One Earth Solar Farm

**Draft Statement of Common Ground with Bassetlaw District
Council**

EN010159/APP/8.5

July 2025

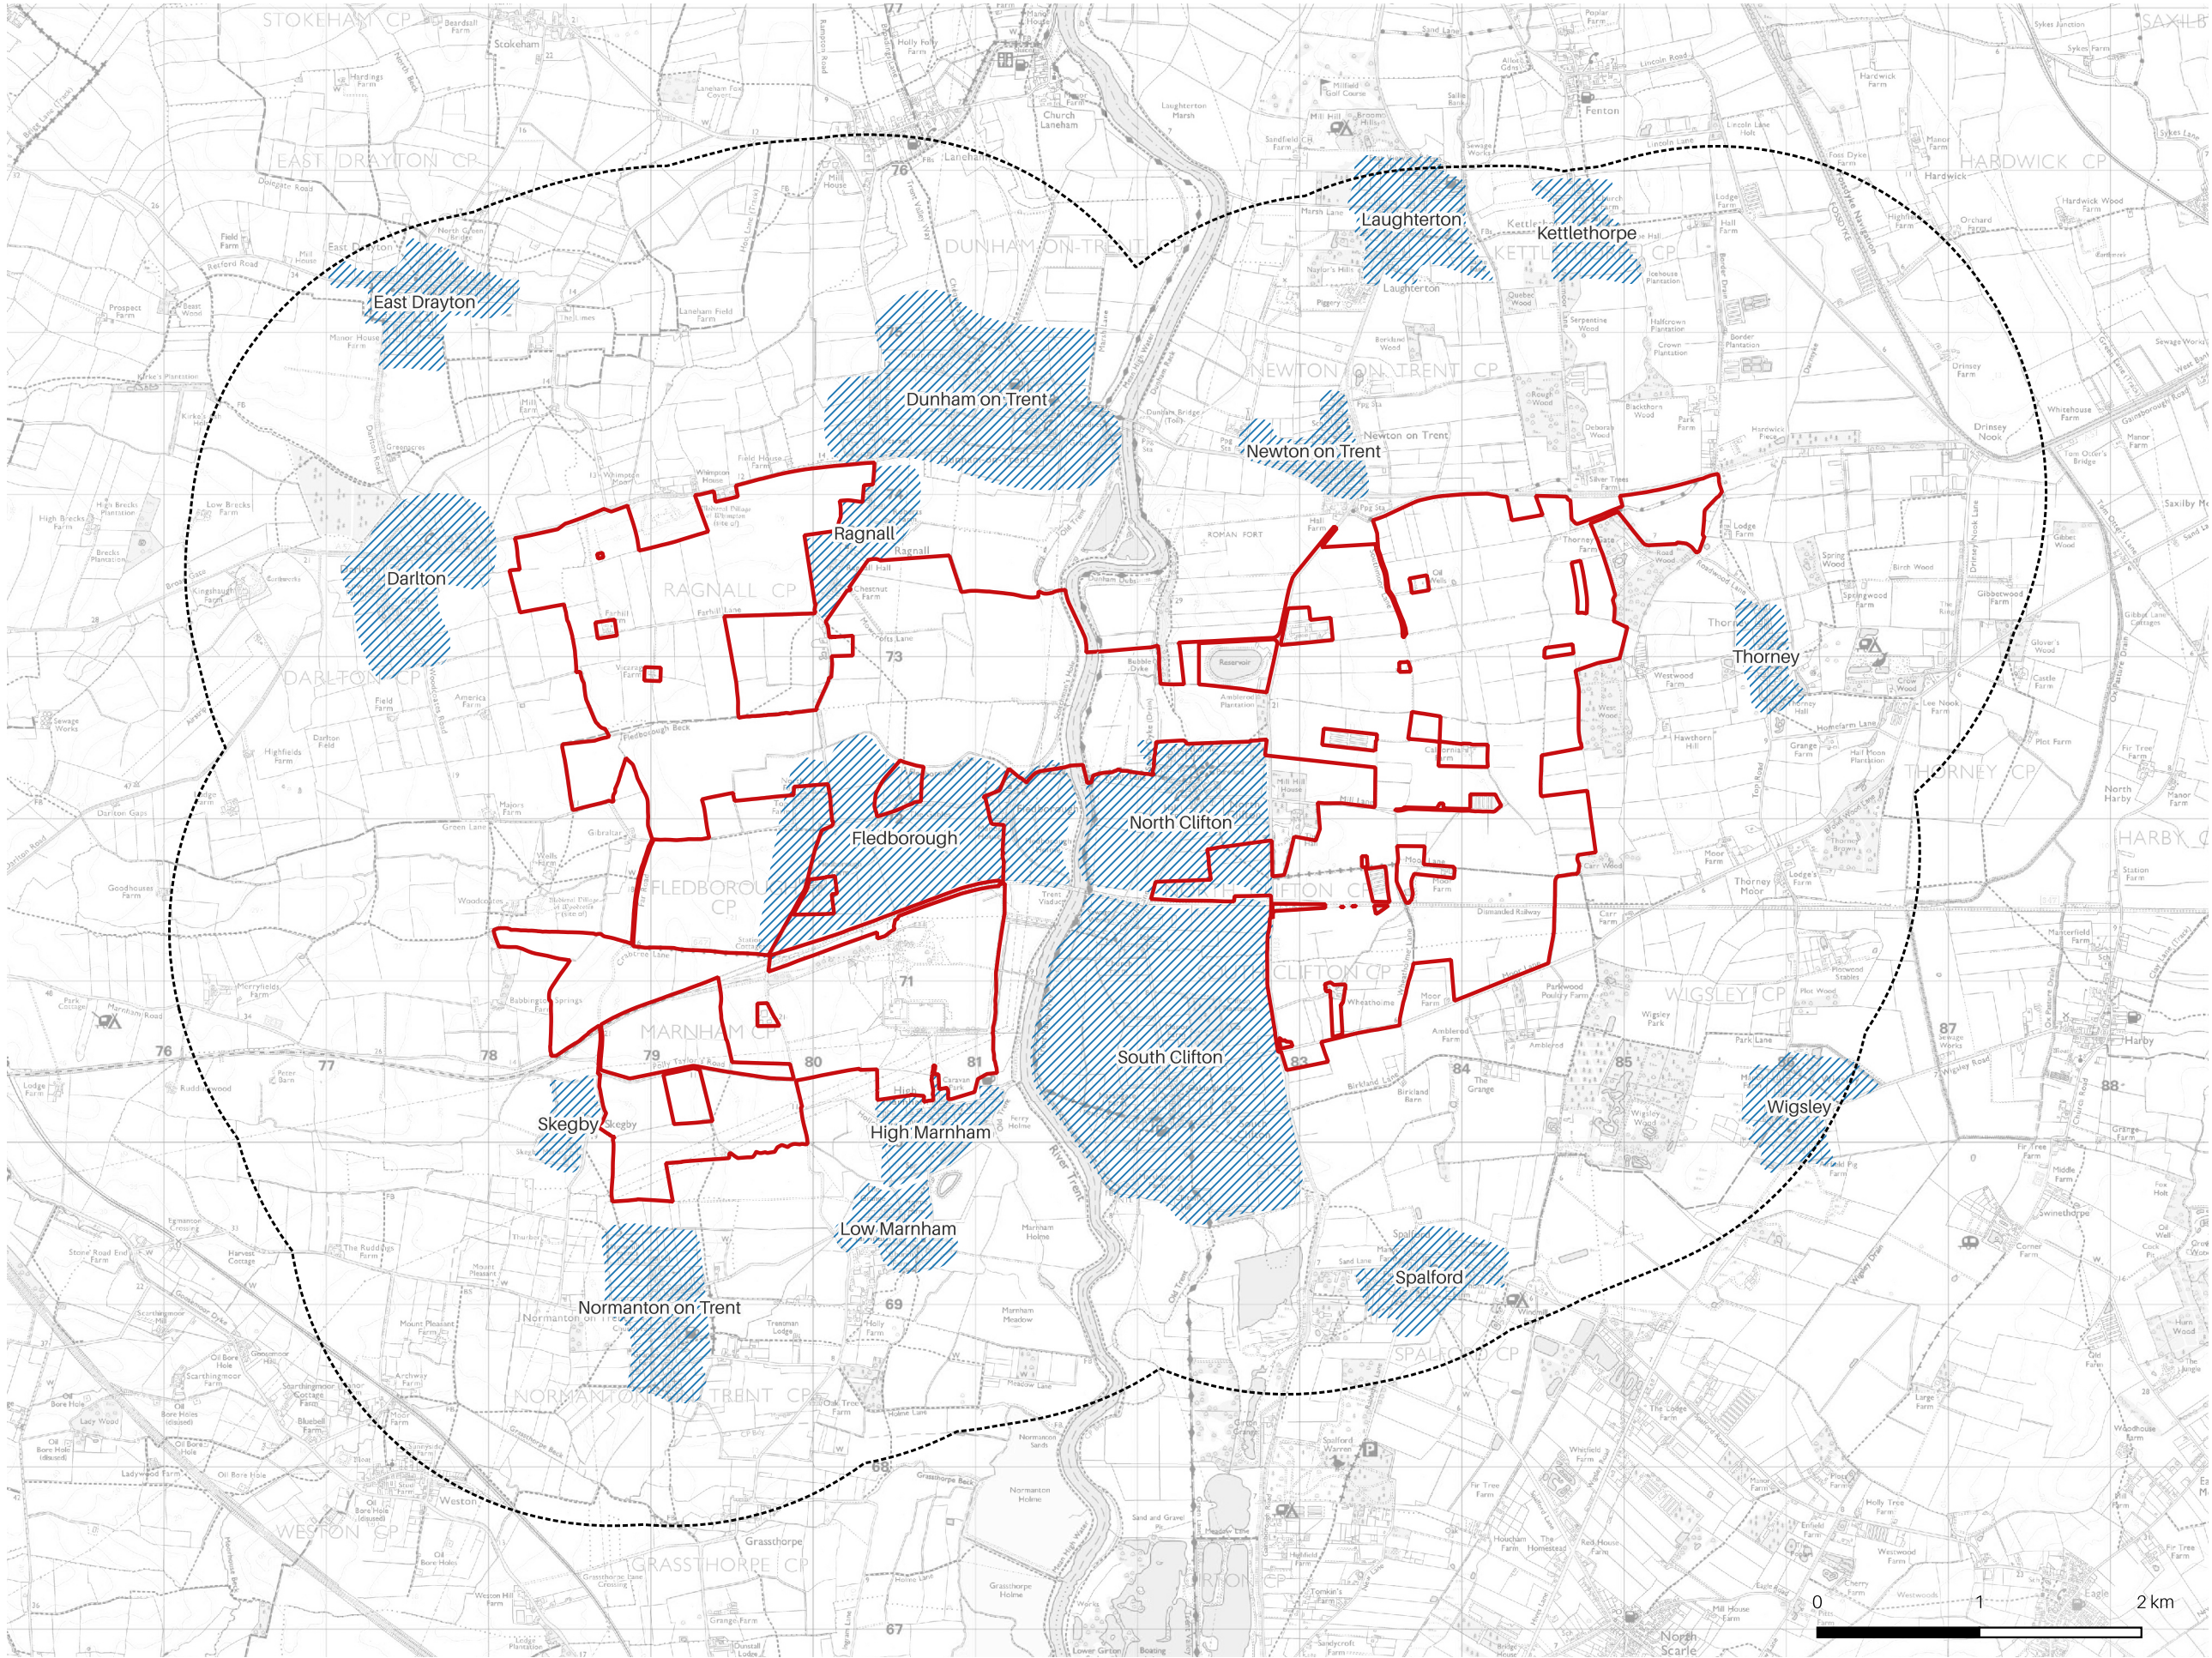
06-03	Scope of landscape receptors	<p>The inclusion of Thorney as a Local Village Character Area following feedback on the PEIR was welcomed.</p> <p>No further comments or concerns on the scope of landscape receptors have been raised to date.</p>	<p>The scope of landscape receptors is agreed.</p> <p>The scope of landscape receptors was updated in the LVIA ES Chapter to include for the suggested additions and refinements.</p>	Agreed

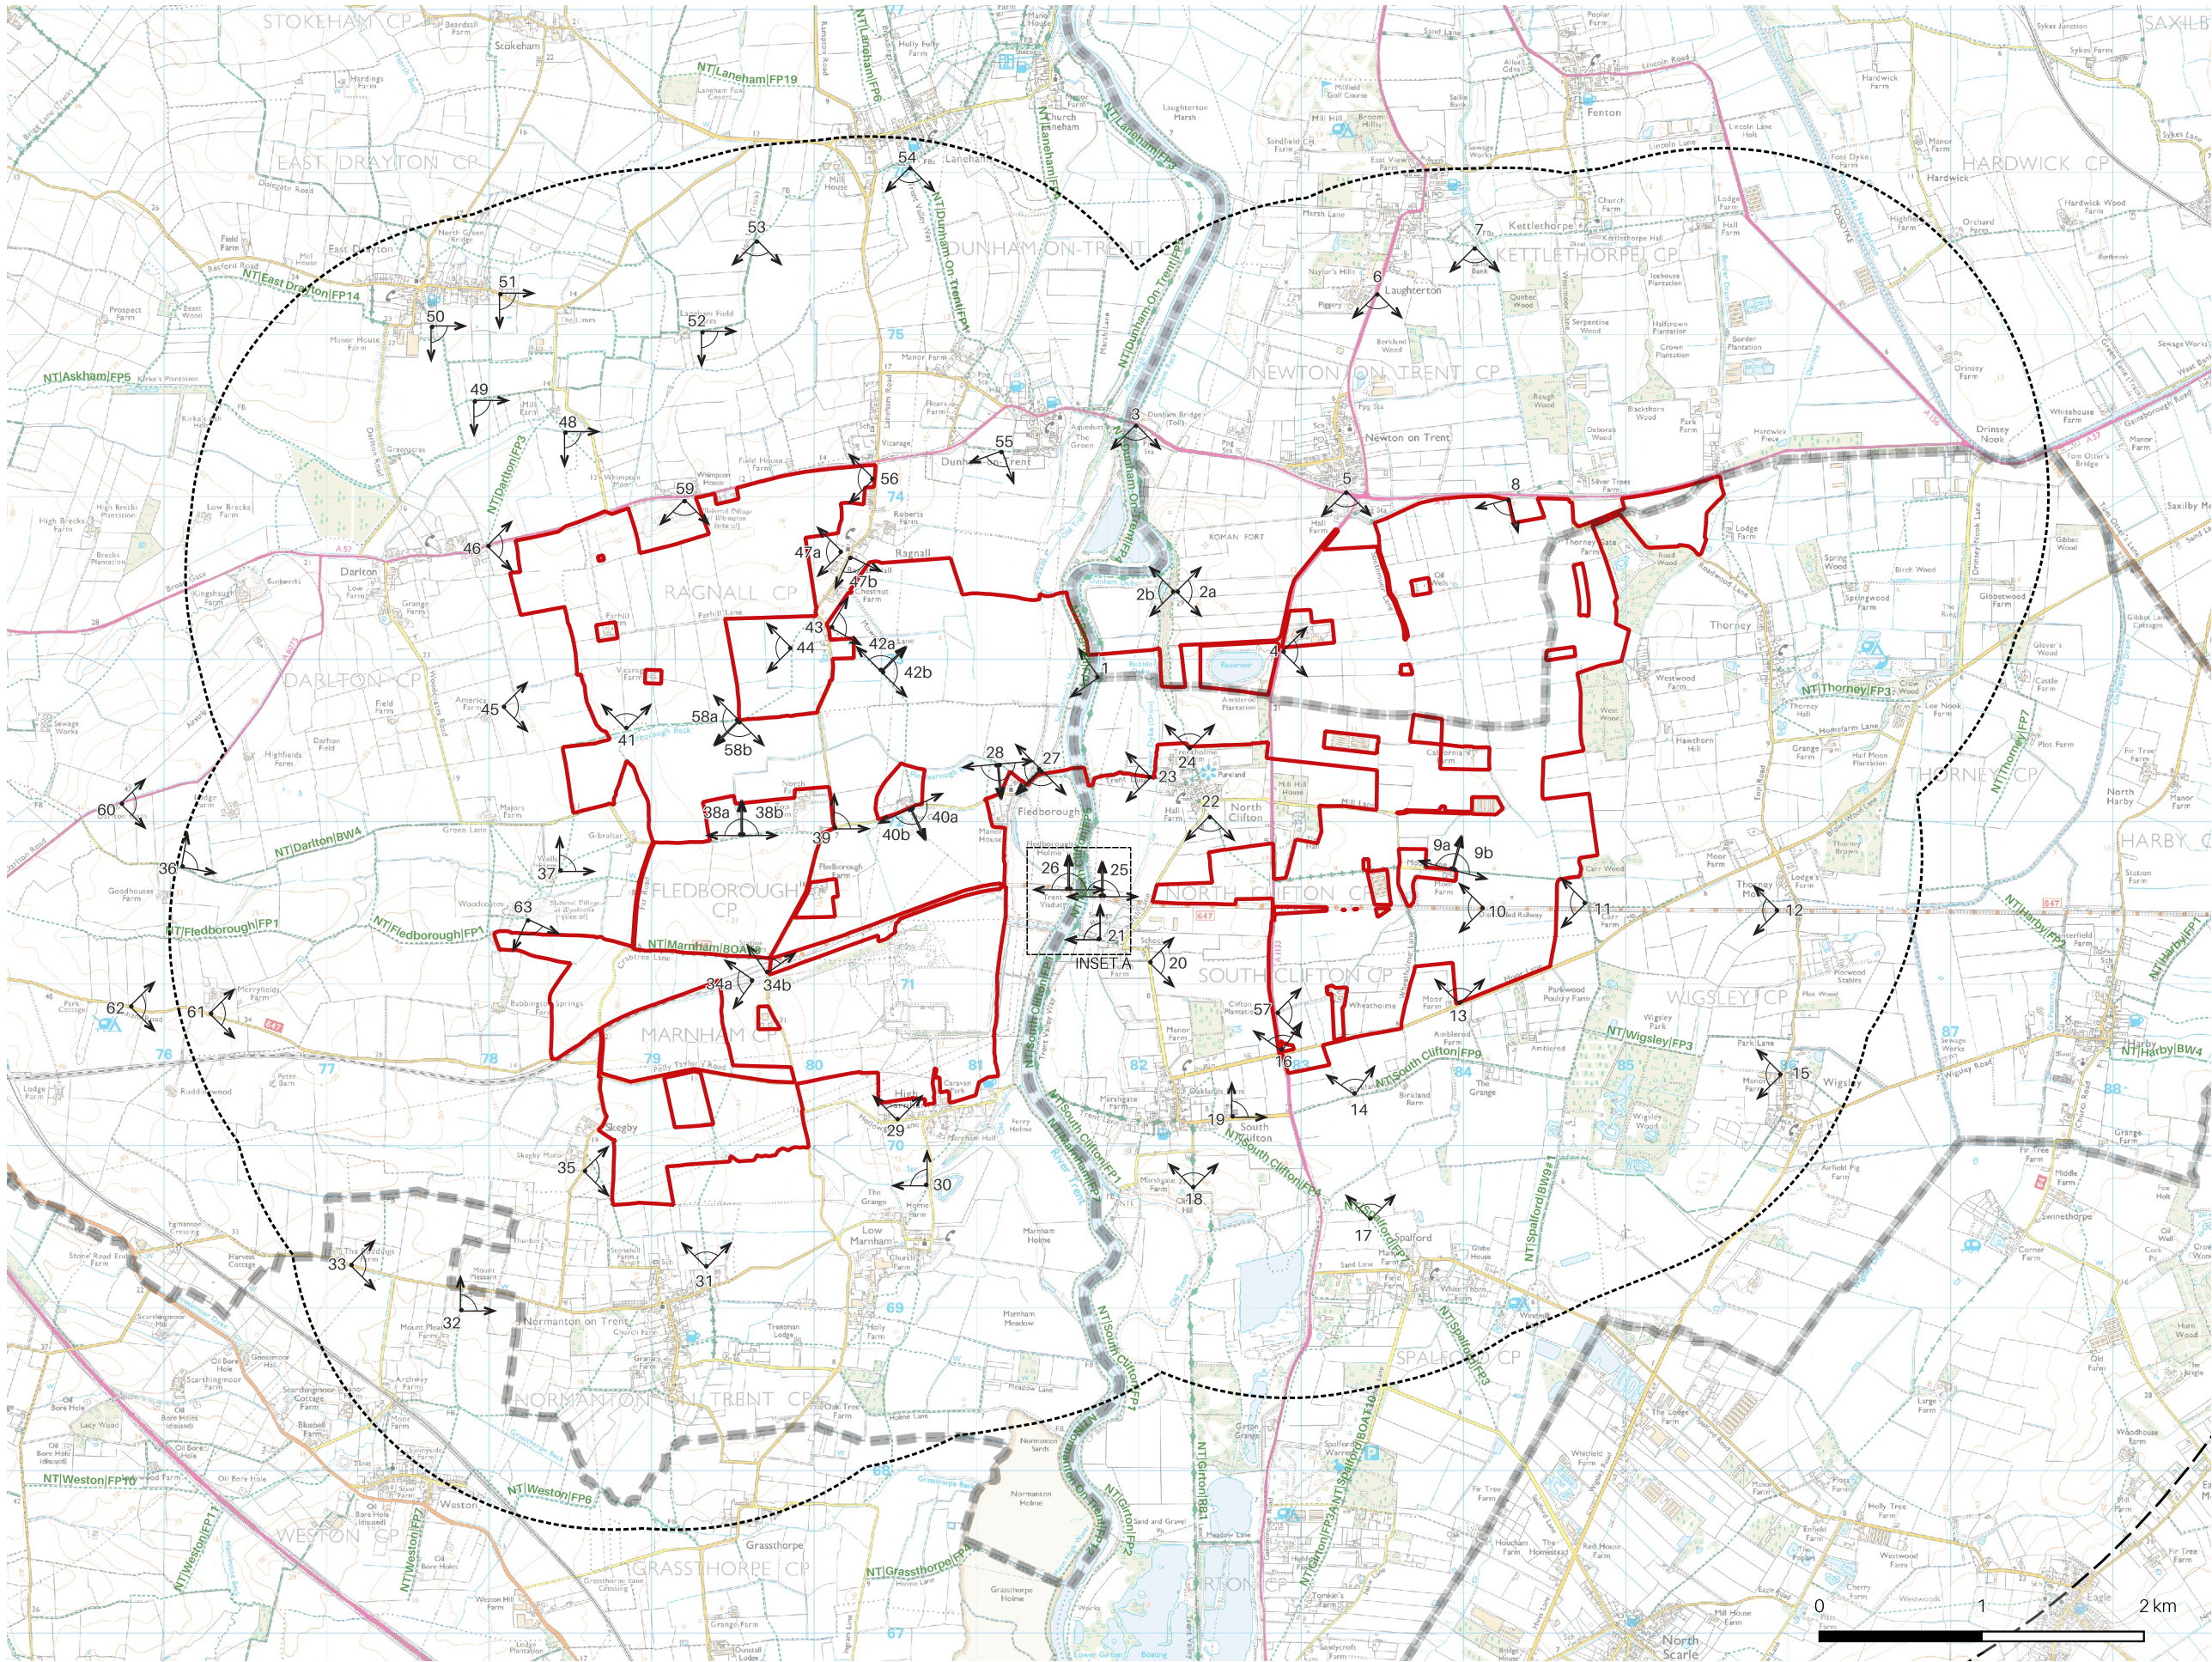
06-04	Scope of visual receptors	Additional visual receptors were suggested following review of the PEIR. No further comments or concerns on the scope of visual receptors have been raised to date.	The scope of visual receptors is agreed. The scope of visual receptors was updated in the LVIA ES Chapter to include for the suggested additions and refinements.	Agreed
06-05	Scope of representative viewpoints	The location of some of the representative viewpoints were questioned and additional viewpoints were suggested following review of the PEIR. No further comments or concerns on the scope of representative viewpoints have been raised.	The scope of representative viewpoints is agreed. The scope of representative viewpoints was updated in the LVIA ES Chapter to include for the suggested additions and refinements.	Agreed
06-06	Scope of photomontages	An additional Type 4 photomontage was suggested from Viewpoint 58 following review of the PEIR. No further comments or concerns on the scope of representative viewpoints have been raised.	The scope of photomontages is agreed. Further discussion was had between the applicant and the District Councils during the preparation of the LVIA ES Chapter regarding the scope of photomontages resulting in agreement that the number and distribution of locations is sufficient.	Agreed
